CITY OF ALBUQUERQUE

Site: Aloha RV Addition

Re: Drainage Ordinance (14-5-2-1) Violation for Erosion and Sediment Control

EROSION AND SEDIMENT CONTROL PLAN

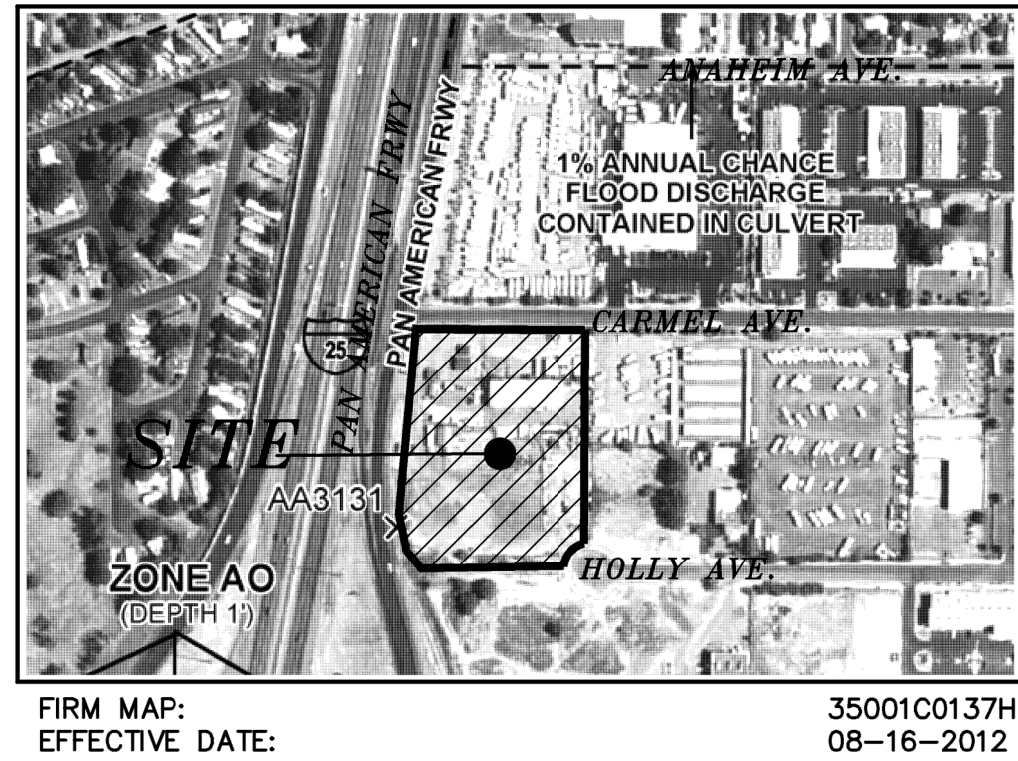
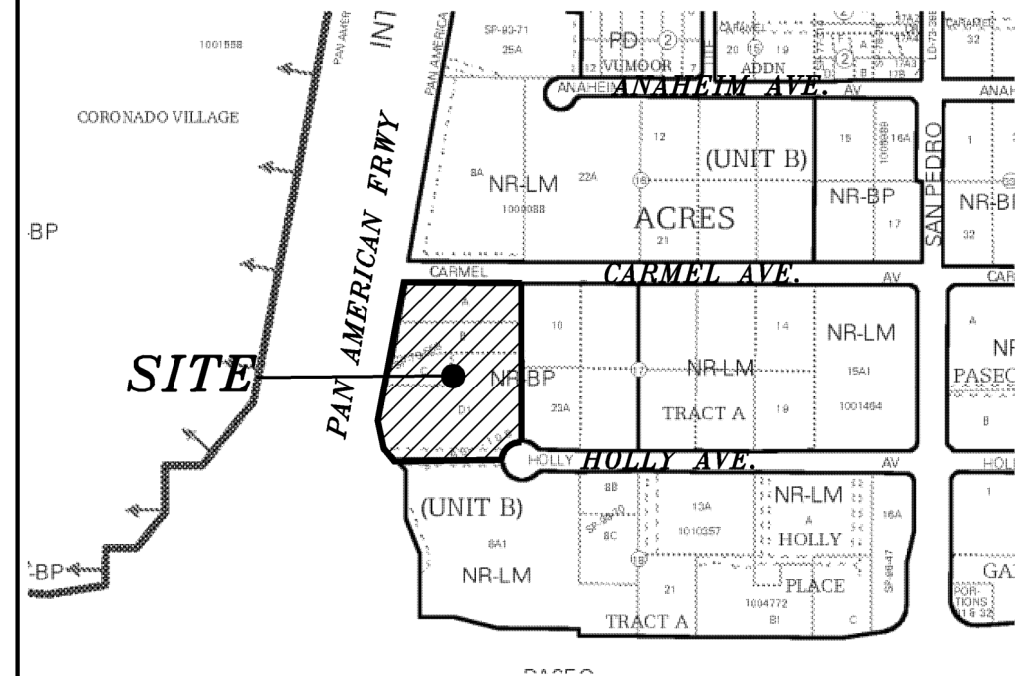
1. Earth disturbance has begun at the site and stormwater controls have not been implemented.

Earth disturbed at site. No sediment BMPs.

1. Implement stormwater controls per approved Erosion and Sediment Control Plan.
